Rezoning Transportation Analysis

Petition Number: 2025-104

Date	Description
9-24-25	First Review (CM)
10-23-25	Second Review (CM)
11-20-25	Third Review (CM)
12-22-25	Fourth Review (CM)

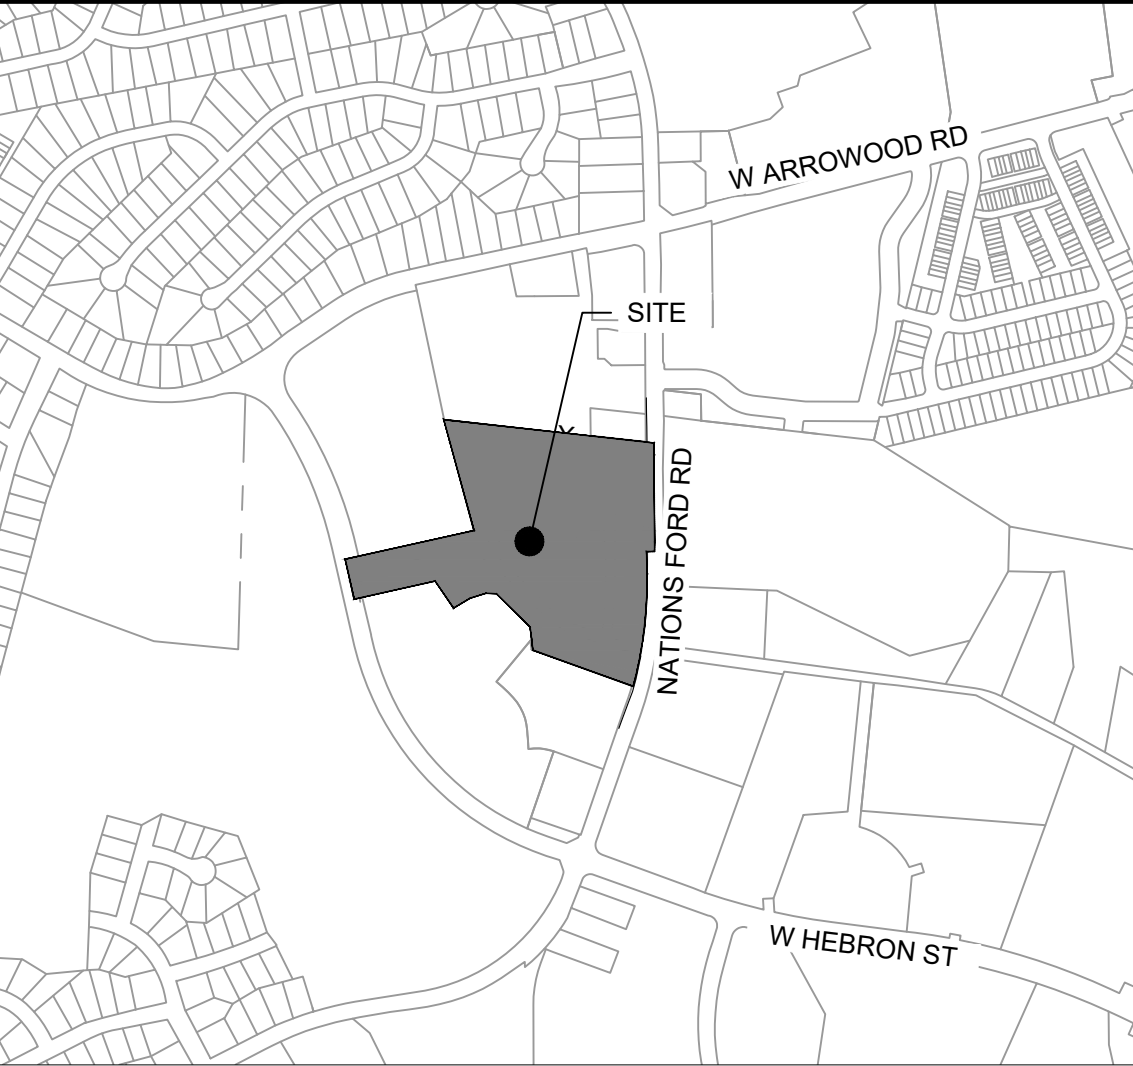
Label and dimension the curb and gutter from the centerline for each road on the site plan.

Clarifying Comment 10.23.25: ~~Revise site plan and conditional note(s) to label Road B and Road C as public or private roads. Add road labels for all roads to site plan. Add conditional note(s) identifying each roadway.~~

Clarifying Comment 10.23.25: ~~Revise site plan and dimension to show minimum 200 feet separation between Road A and Nations Ford Road per CLDSM requirement for intersection separation along collector roadway.~~

Clarifying Comment 10.23.25: In coordination with subdivision shift stub road to larger parcel for better chance at future connection.

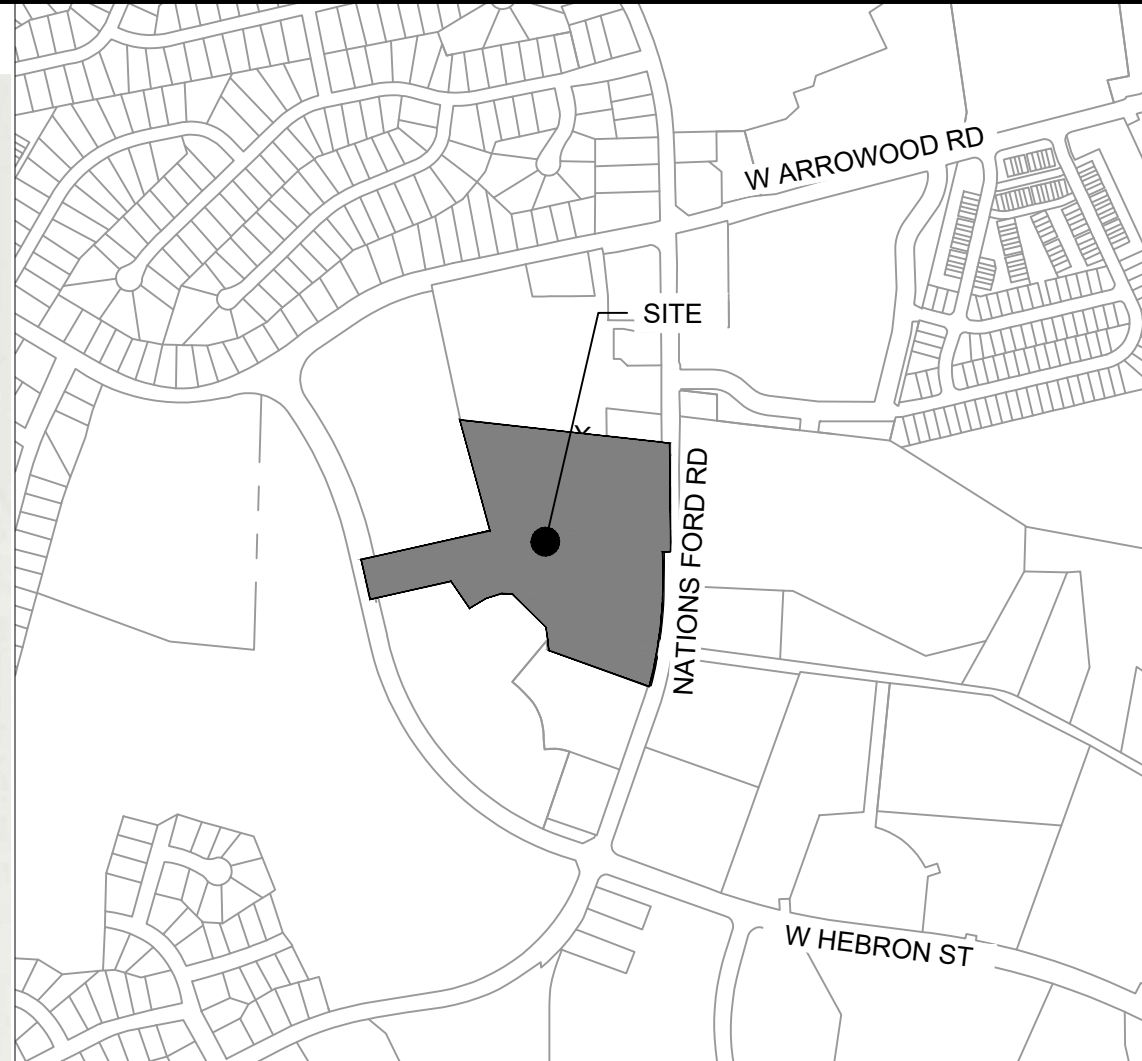
16. **New Comment 10.23.25:** Update the site plan road dimensions for Old Hebron Road, Road A, Road D, Road C to dimension based on standard 2.5ft curb and gutter instead of valley gutter, revise callout on site plan to reference 2.5-foot curb and gutter and not valley gutter. Please add the CLDSM detail on the site plan within the road labels for each (which will give flexibility per CLDSM to construct the appropriate section during permitting). Road B and C can remain without specific CLDSM label.

Clarifying Comment 12.22.25: Old Hebron Road dimensions need to be updated to match U-07B for 2.5ft standard curb. Pavement width should be 30ft and total roadway width (back of curb to back of curb) is 35ft.
